From: Simon Davis
Sent: 10 November 2020 16:13
To: Planning Scanning
Subject: FW: Land at Stakers Farm, Yapton - Y/71/20/RES & Y/72/20/RES

Application Correspondence "Correspondence on drainage"

From: Laura Gibbons <Laura.Gibbons@arun.gov.uk>
Sent: 10 November 2020 15:25
To: Arek Kadlec [REDACTED]
Cc: Paul Cann <Paul.Cann@arun.gov.uk>; Chris Harrison [REDACTED] Christian O'Brien
[REDACTED] Brian Chamberlain [REDACTED] Jonathan Merrick
[REDACTED] Scott Webster [REDACTED] Simon Davis
<Simon.Davis@arun.gov.uk>
Subject: RE: Land at Stakers Farm, Yapton - Y/71/20/RES & Y/72/20/RES

Odyssey		Page 1
Tuscany House	NORTH END ROAD	
White Hart Lane	YAPTON	
Basingstoke RG21 4AF	70 UNITS	
Date 26/07/2020 21:53	Designed by AK	
File 19-156 70 Units	Checked by	
Micro Drainage		Network 2020.1

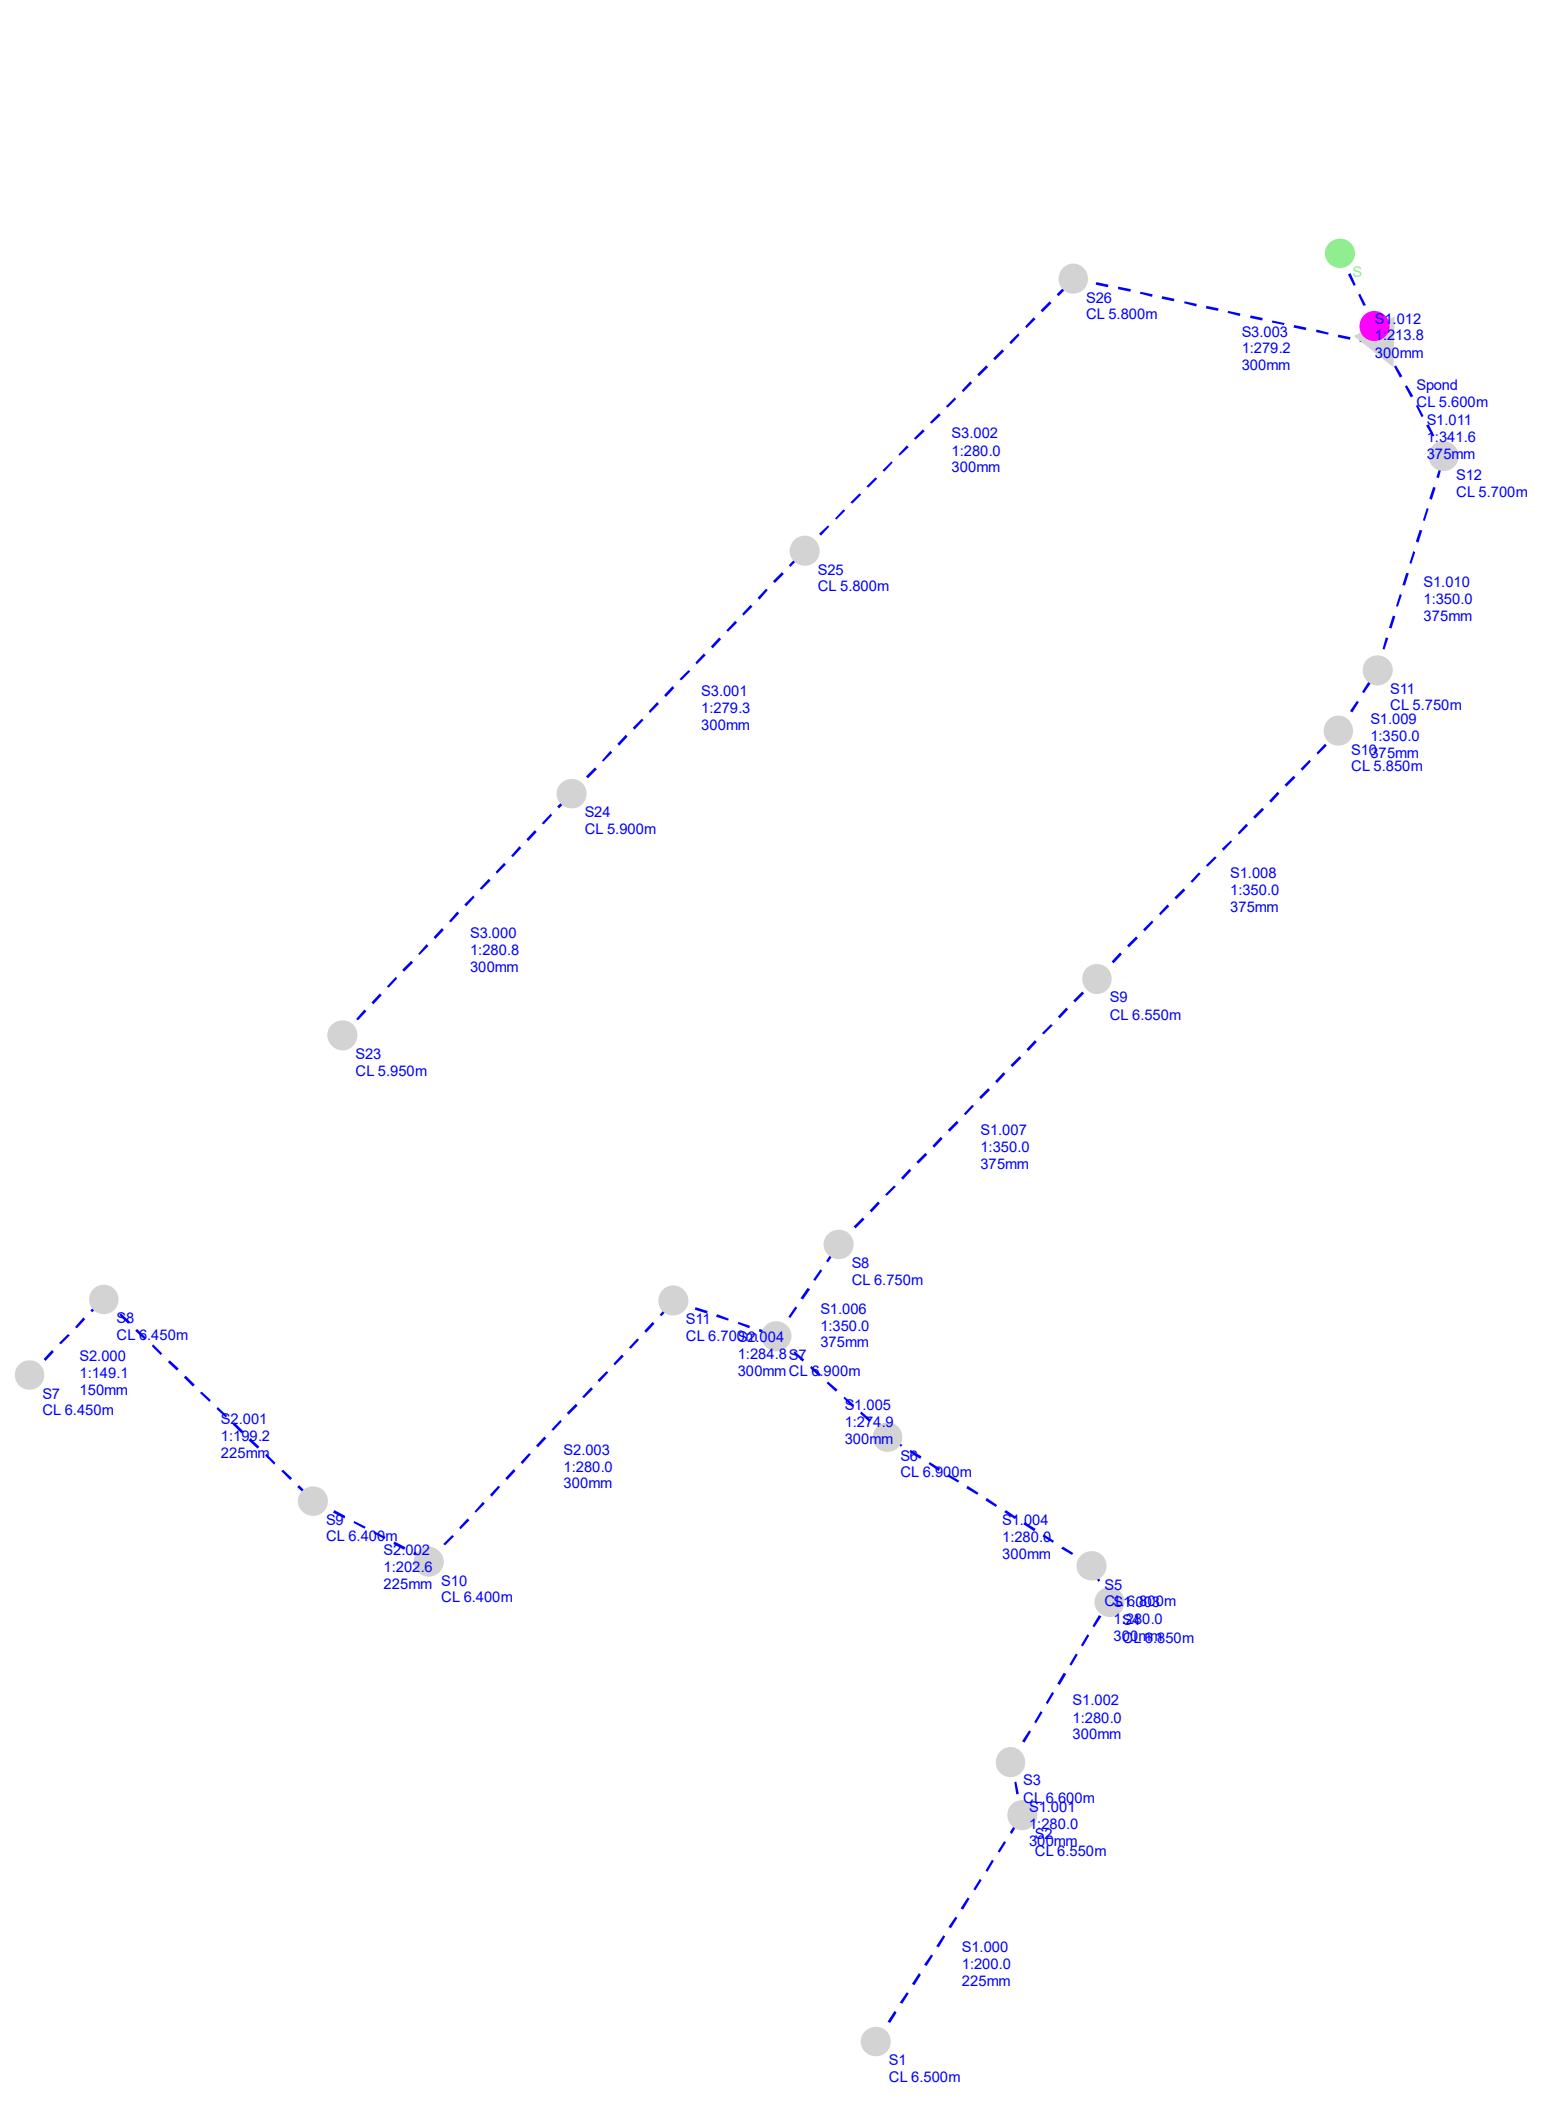
- All structures half draining within 24 hours for the 1 in 10 year plus 40% climate change event.
- All pipes achieving 1m/s full bore velocity.
- All infiltrating devices must cater for the 1 in 10 year storm between the invert of the entry pipe to the soakaway, and the base of the structure.
- All SuDS features must be located outside of the utilisable open space. The LAP must not be within the basin. This is supported by the below text in blue.
- Adequate freeboard must be provided on open SuDS features.

- Your comment *"A half drain time of less than 1440minutes must be provided for the 1 in 10 year plus climate change event, with urban creep allowance. This does not appear to be being achieved"*. As per Paul's e-mail we have used climate change to assess the 'no flooding' scenario for the 1 in 100 yrs event but designed for half drain on 1 in 10 year without climate change, as is the norm

- Your comment *"Half drain time results for lesser events for the permeable paving network must be provided."* We understand that this comment comes from the wish to half-drain the calculated storage within 24 hours to provide sufficient storage for a subsequent storm. Whilst the majority of the permeable paving system drains its half-volume within the 24 hours for the design storm of 1 in 10 yrs 48 hours duration (which is a suggested storm duration in CIRA C753 document, section 24.2.3 "Rainfall to be used in calculations" and "Design rainfall" sub-section) few sections exceeded the 24 hour time period. We have however catered for such instance and provided sufficient storage within the system and a volume of the subsequent 1 in 10 yrs storm
